Ribble Valley Borough Council
By email

Your ref: 3/2024/0996
Our ref: DC/24/3050
Date: 06-JAN-25

Location: 98 Rochester Road and land adj 94 Ribchester Road Clayton-Le-Dale BB1 9HQ
Proposal: Approval of details reserved by conditions 9 (SW drainage), 12 (drainage scheme)

Further to our review of the submitted documents, unreferenced drawing named Proposed Drainage Layout in Document Surface and Foul Water Drainage Scheme - Dated 2024, United Utilities recommends that condition 9 and 12 are not discharged. This is because

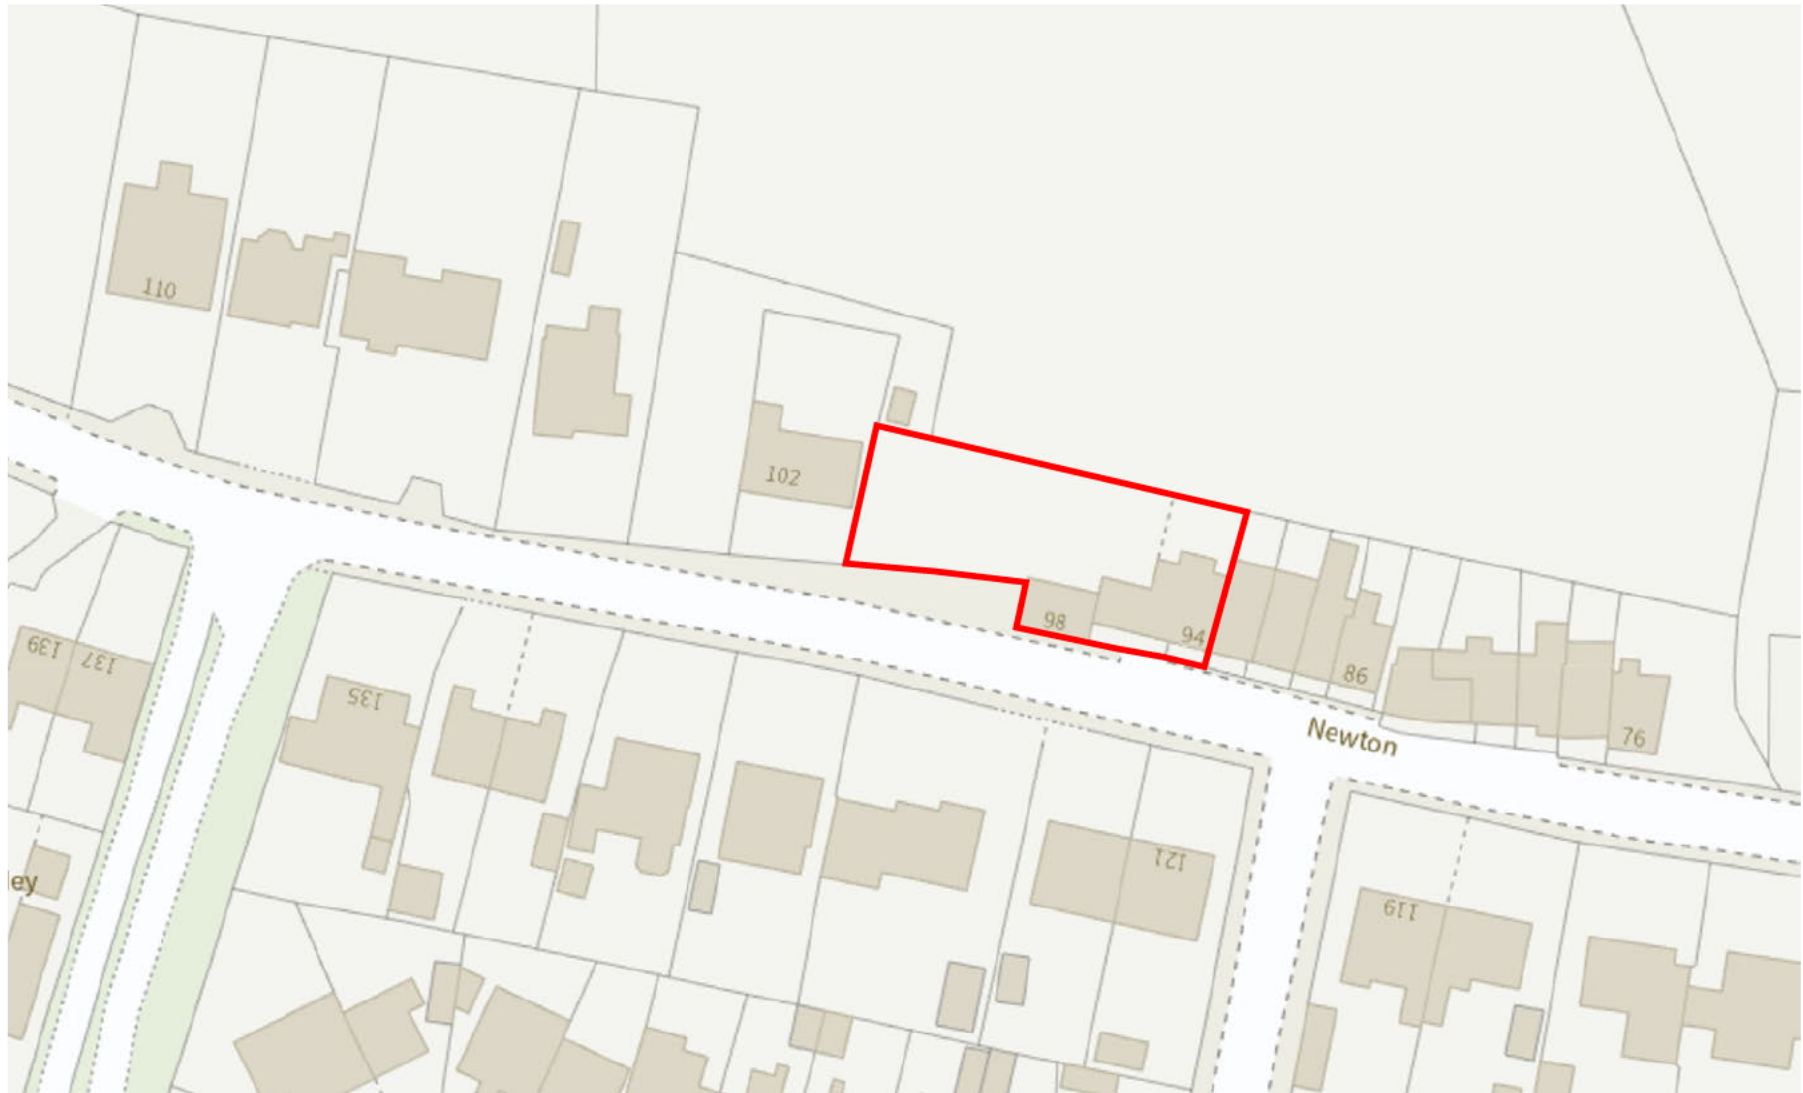
-It is unclear how the connection is being made with the public wastewater network.

-The sewer shown on our records is being assumed to be a combined sewer. It is shown as a foul only sewer.
